## **SSD-90337724 – 1 King Street, Concord West (Demolition, Remediation and Associated Works)**

**Re:** SSD-90337724 – Demolition, Remediation and Associated Works – 1 King Street, Concord West

Figure 11 Proposed Construction Site Access

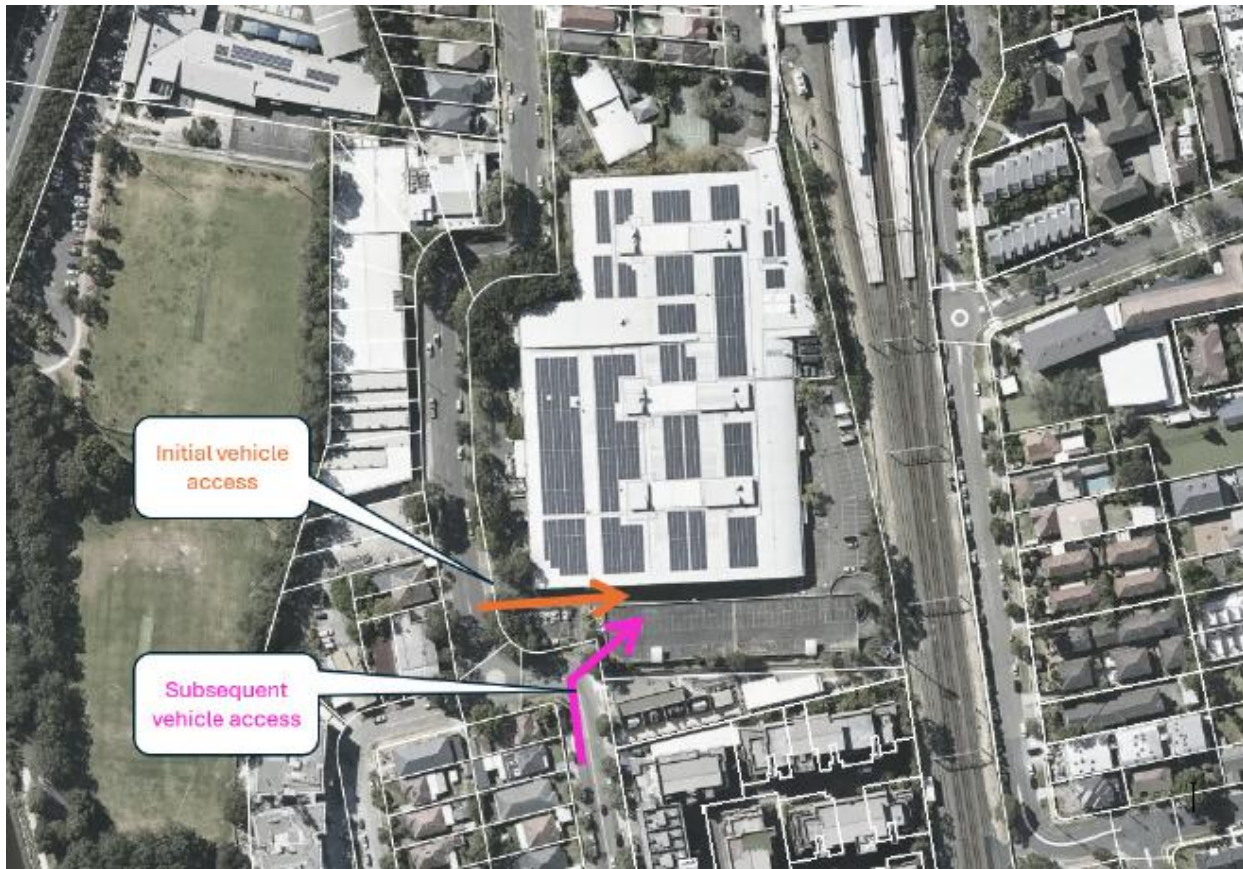
## **9. Construction Traffic, Safety, Child Protection, and Work Hours**

**Concerns:** Narrow streets, heavy vehicle movements, risks to families, children, elderly residents, and emergency access.

- Establish mandatory construction vehicle-free zones on 166-49 George Street, Conway Avenue, Rothwell Avenue, Victoria Avenue, and King Street.
- Continuous driveway access and emergency vehicle access at all times.
- On-site traffic controllers for heavy vehicle manoeuvres.
- No queuing of vehicles on George Street.

Figure 12 Proposed Stormwater Pipe Diversion

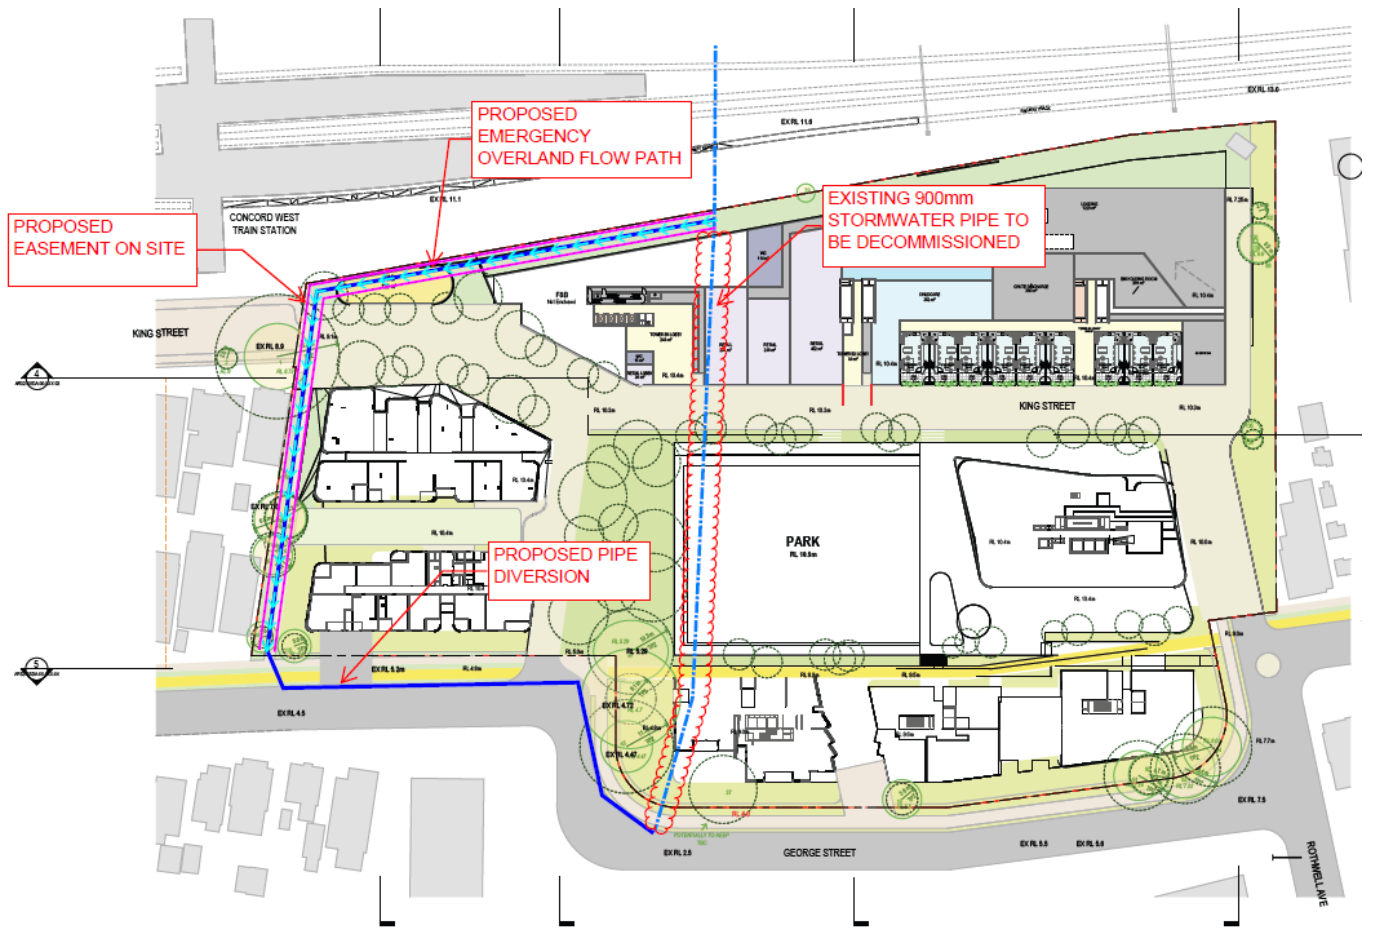
### **1. Stormwater Drain Adjacent to Our Home**

**Concerns:** Permanent structural risk; no assurances regarding footings, groundwater, or settlement.

- Property-specific structural and hydrogeological assessments with detailed modelling.
- Relocation or redesign if risks are identified.
- Protective measures such as retaining walls, underpinning, or waterproofing.
- Long-term monitoring and maintenance program.
- All assessments and mitigation measures incorporated as enforceable conditions of consent.
